DRB Application No.: 09DRB-70317 Project # 1002936  
 Project Name: JADE PARK MOBILE HOME  
 Agent: RHOMBUS CONSULTING Phone No.:

Subdivision Name: JADE PARK MOBILE HOME SUBDIVISION BLOCK 5 LOT 16A & 17A

**July 15, 2009  
DRB Comments**

**RE: Lots 16 & 17, Jude Park Mobile Home Subdivision**

**PLAT
OF
LOT 16-A & 17-A, BLOCK 5
JADE PARK MOBILE HOME SUBDIVISION**
WITHIN THE ELENA GALLEGOS LAND GRANT
PROJECTED SECTION 24, T. 11 N., R. 3 E.
ALBUQUERQUE, BERNALILLO COUNTY
SEPTEMBER, 2009

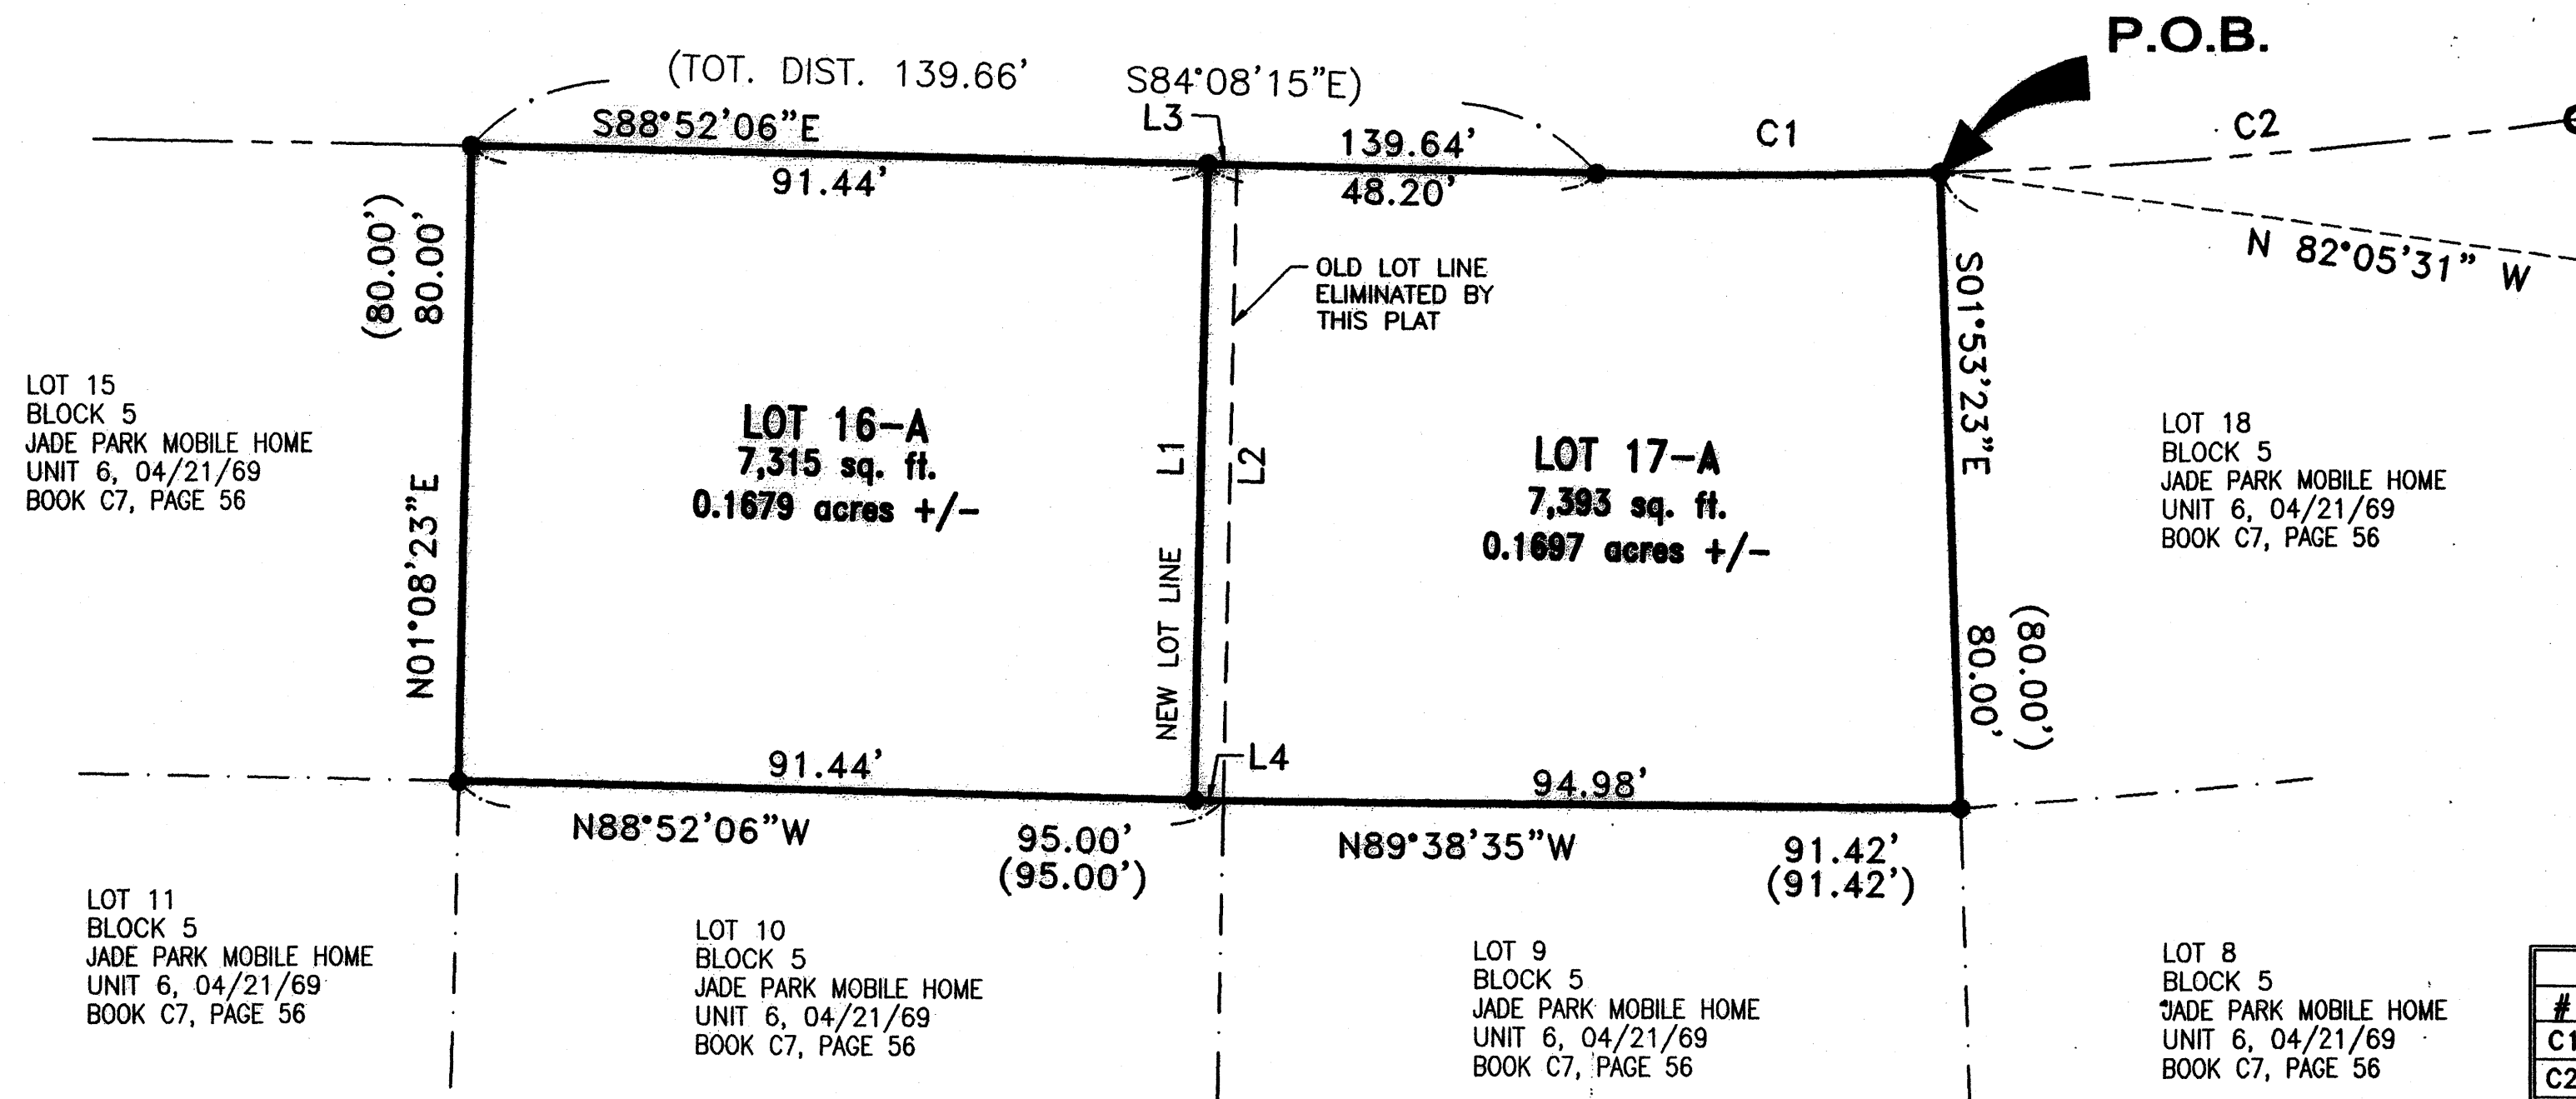
Based on Sketch Plat of April 29, it appears approximately 3.5 feet is needed to be transferred.

Plat should include the distance the property line will be adjusted

How far is the property line proposed to be moved? It appears approximately 4 feet is needed.
